## PLAN REVIEW SHEET

Date: January 22<sup>nd</sup>, 2024

Petition #: 2023-074

**REZONING SITE PLAN**  
REZONING PETITION:  
2023-074

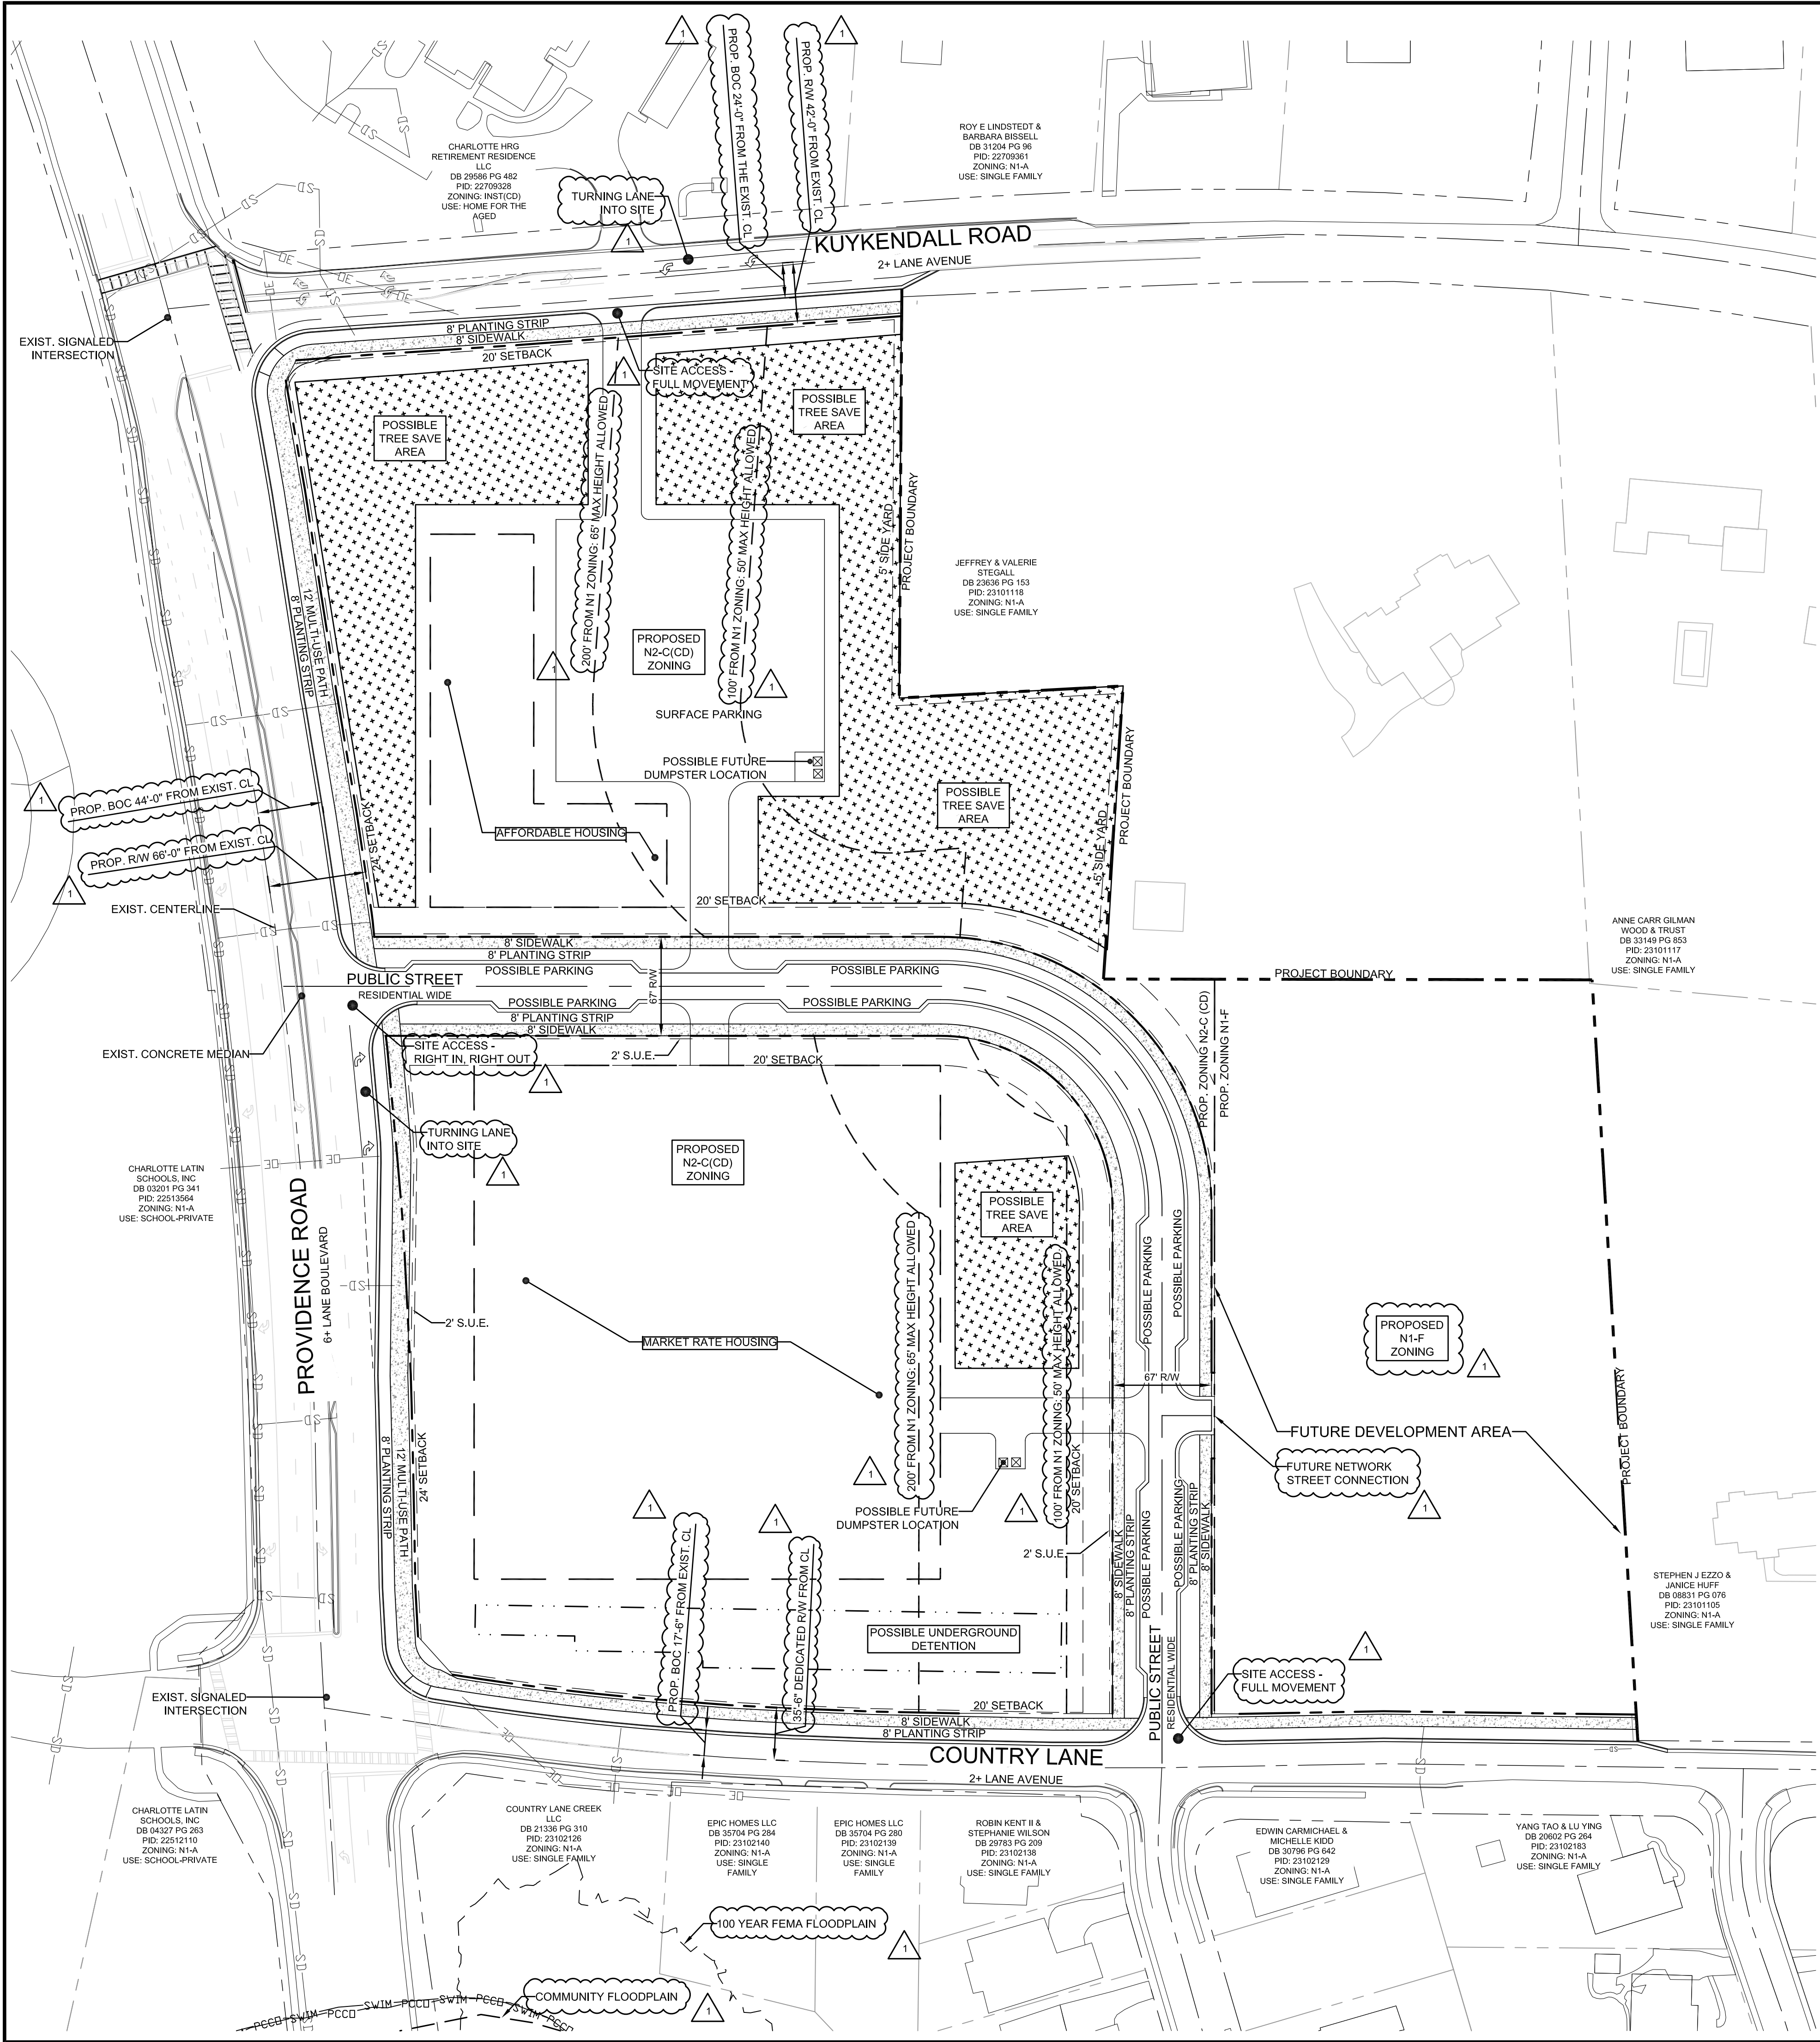
The site is located at 9631 Providence Road and served by CATS bus route #61x. CATS requests the construction of ADA-compliant bus standard details 60.05A Kuykendall Road. The final location will be coordinated with the developer during the Land Development plan review process.
